# City of Albuquerque

December 9, 1987

RE: DRAINAGE & GRADING PLAN SUBMITTAL OF ALBUQUERQUE REGIONAL  
DETENTION FACILITY RECEIVED NOVEMBER 24, 1987 FOR BUILDING  
PERMIT (J-14/D74)

ALBUQUERQUE
REGIONAL DETENTION FACILITY
324 LOMAS BLVD. N.W.
GRADING AND DRAINAGE PLAN

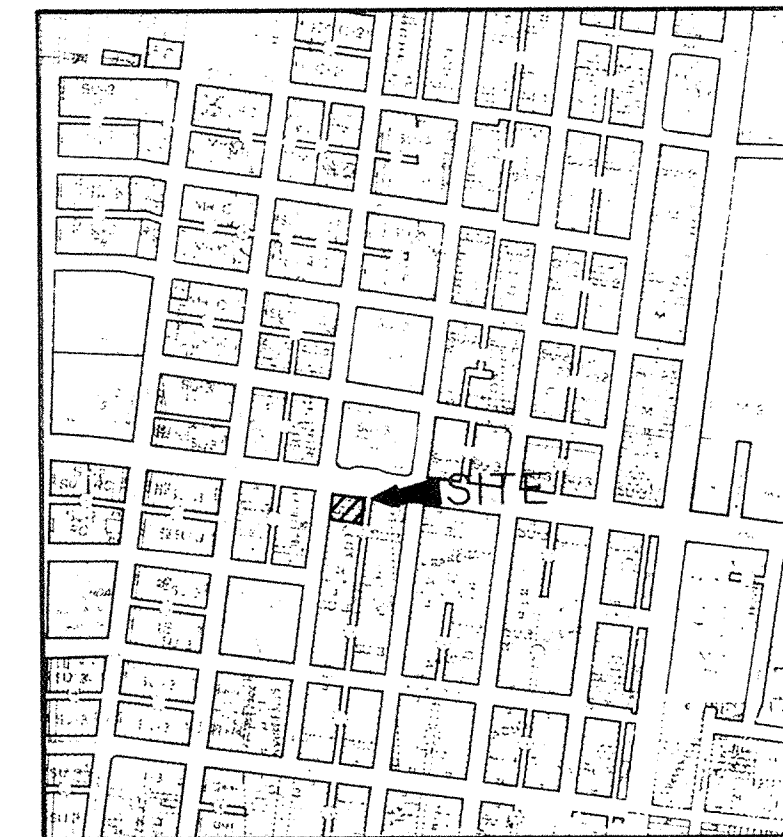
1. In the hydrology table, the "C" value is incorrect if  
the existing site is a combination of asphalt and  
building.
2. If the proposed building footprint is the same as the  
perimeter property lines, show the following:
  - a. finish floors of adjacent property building;
  - b. how roof will drain to the single 8" PVC  
drainline shown;
  - c. where parking areas are provided.

3. All the drive pads shown are shown as being new, therefore, how is access or parking provided with these drive pads.
4. If the structure is to be multi-story, then shown the finish floor elevations for all the levels and how each will drain.
